Application number: 2025/91770	
What is the application for?:	Outline application for erection of residential development (5 dwellings)
Address of the site or building:	Land off Station Road, Meltham, HD9 4NL
Postcode:

Type of comment: An objection	
Do you wish your comments to be published on the website anonymously?	No
<p>I am writing to formally object to the above planning application for the proposed development of five residential properties at Land off Station Road, Kirklees. As a resident of Station Road, which is directly affected by the proposed development, I have serious concerns regarding the impact this would have on privacy, road safety, ground stability, drainage, and the proximity of the access road to existing homes and infrastructure.</p> <p>1. Loss of Privacy</p> <p>The proposed layout and orientation of the new dwellings would result in a significant loss of privacy for existing residents, particularly those whose properties are overlooked by the proposed site.</p> <p>The positioning and height of the new dwellings, along with any upper-floor windows, would allow direct views into neighbouring gardens and habitable rooms. Additionally the proposed driveways an

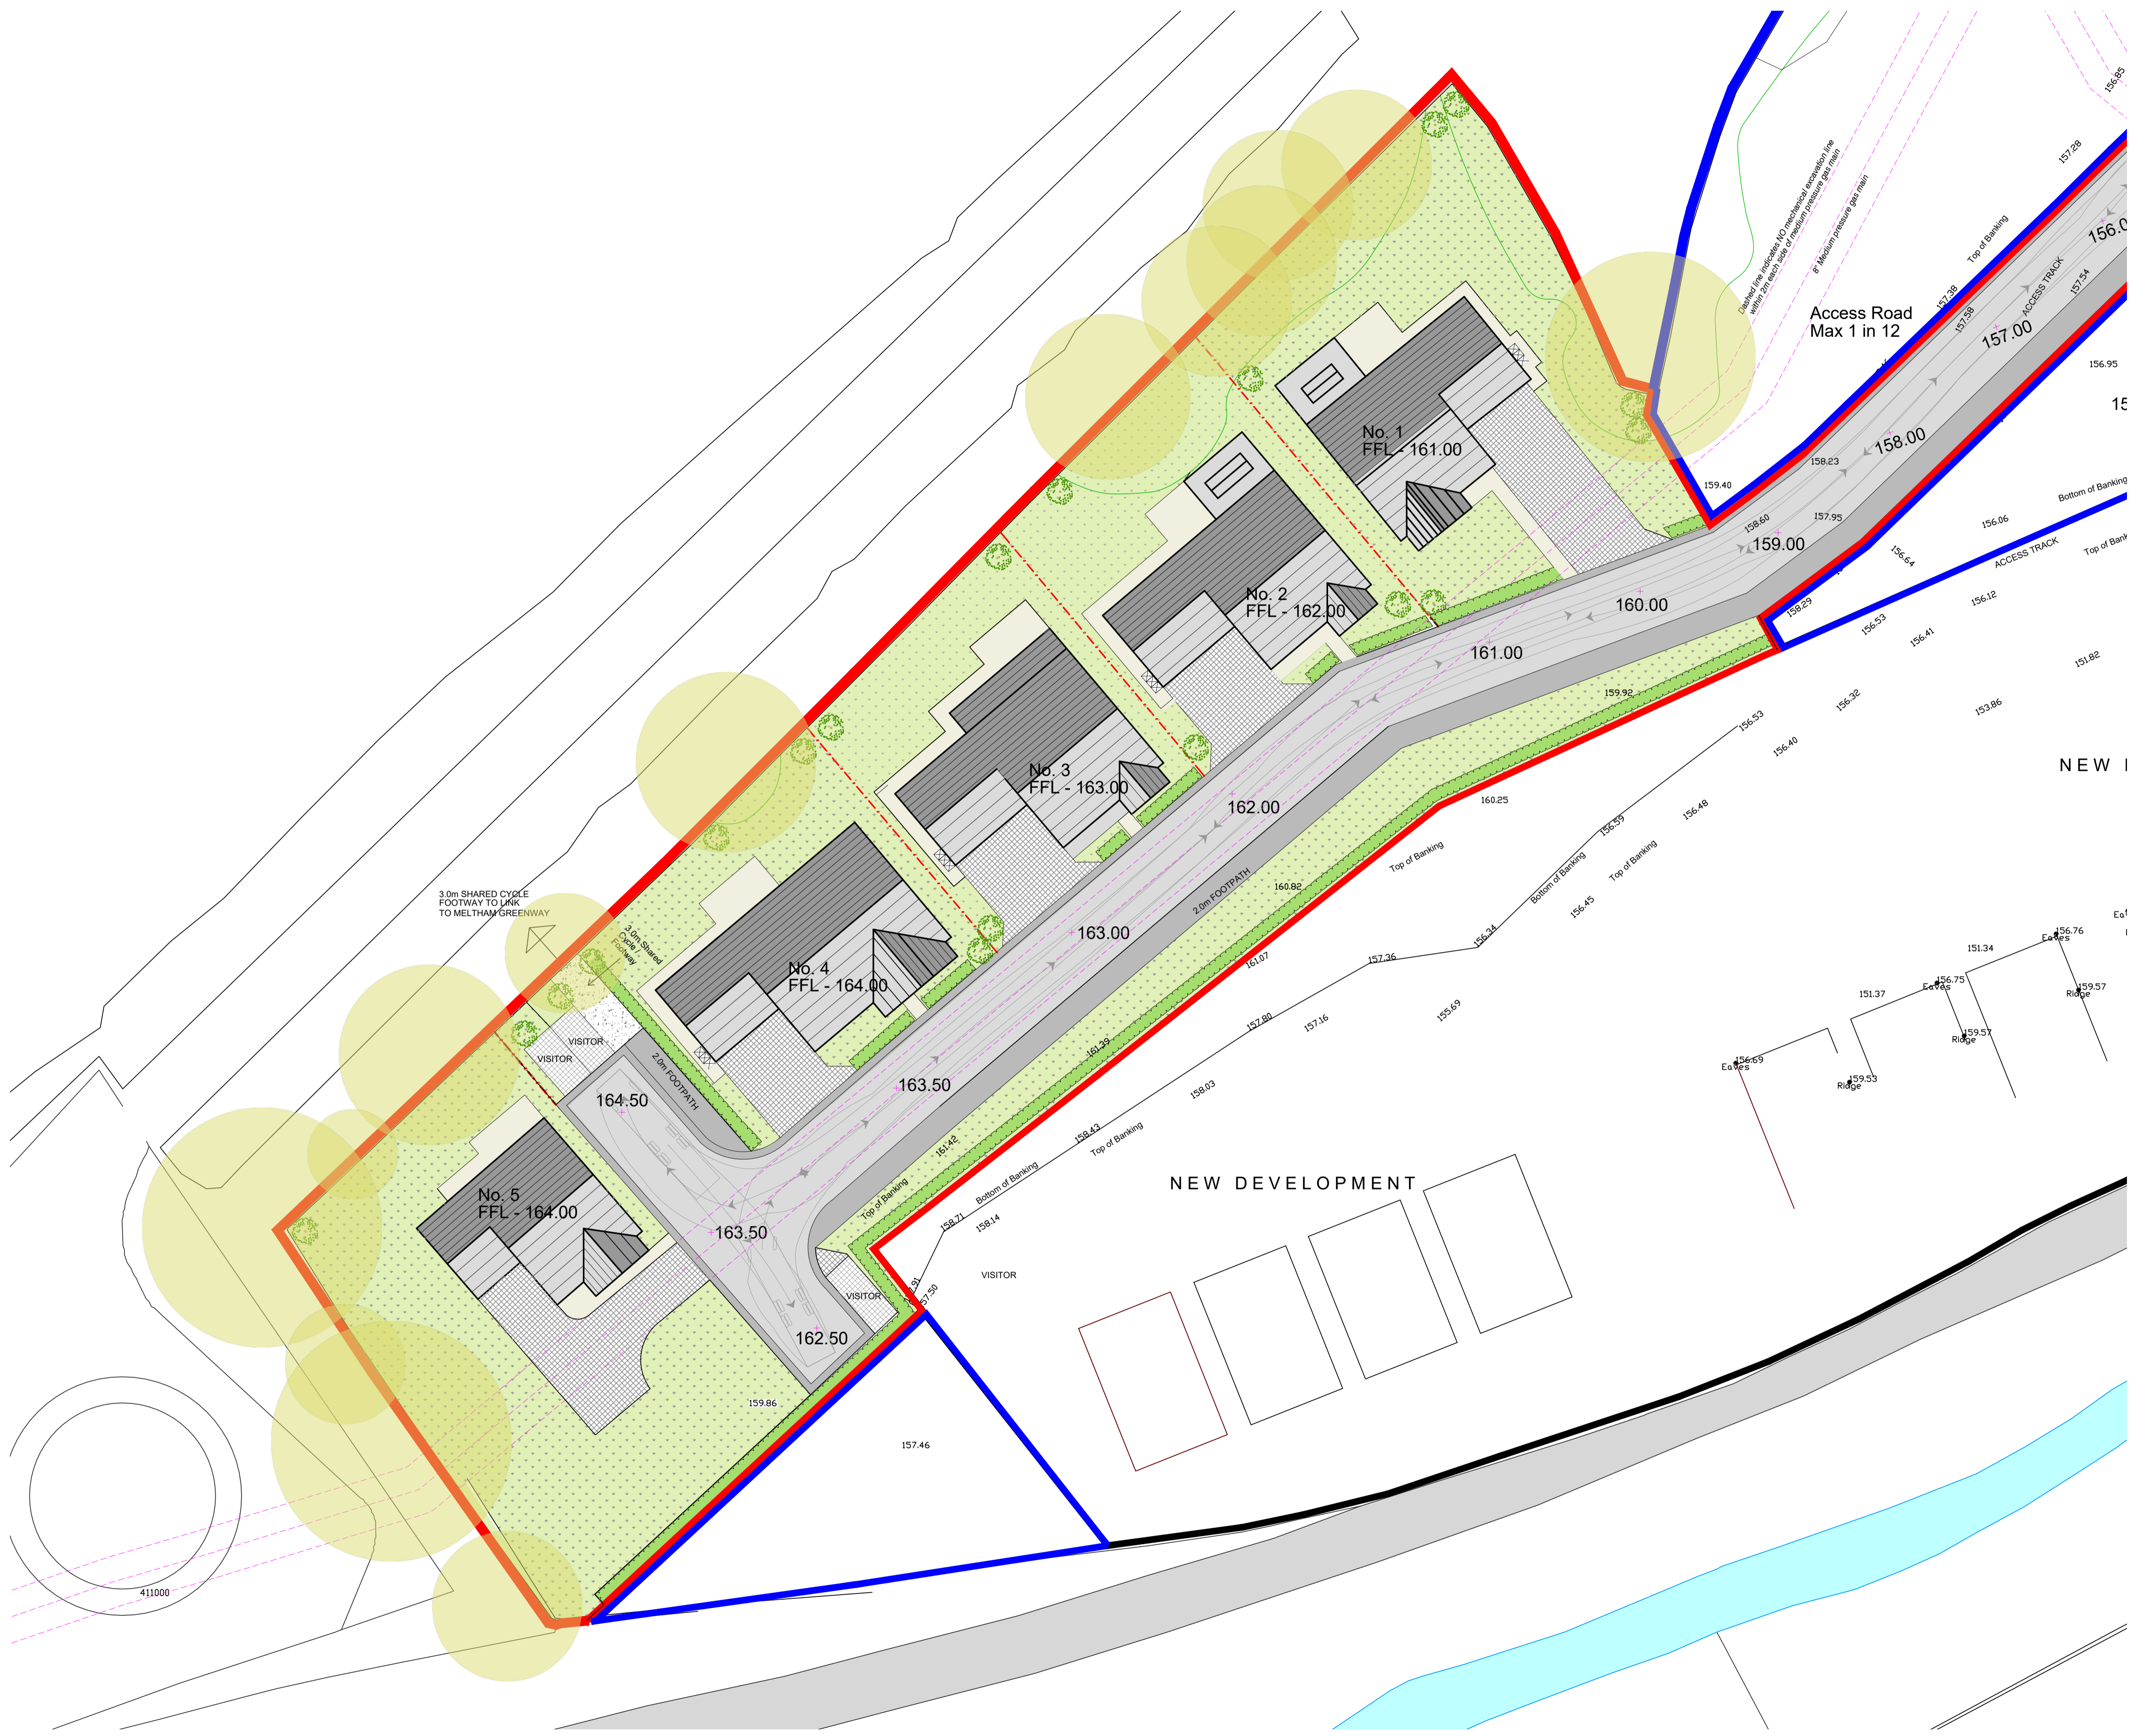
The proposed access road runs extremely closely at an elevated level to existing property at Station Road, raising serious concerns about safety, noise, vibration, and loss of amenity. Critically, the access road is understood to be situated directly over a gas pipeline, which poses a serious safety risk. Any construction or increased traffic over this area must be fully assessed by the relevant utility providers and safety authorities. The application does not appear to address these risks.

Reassess the access road's location and its proximity to existing homes and gas infrastructure.
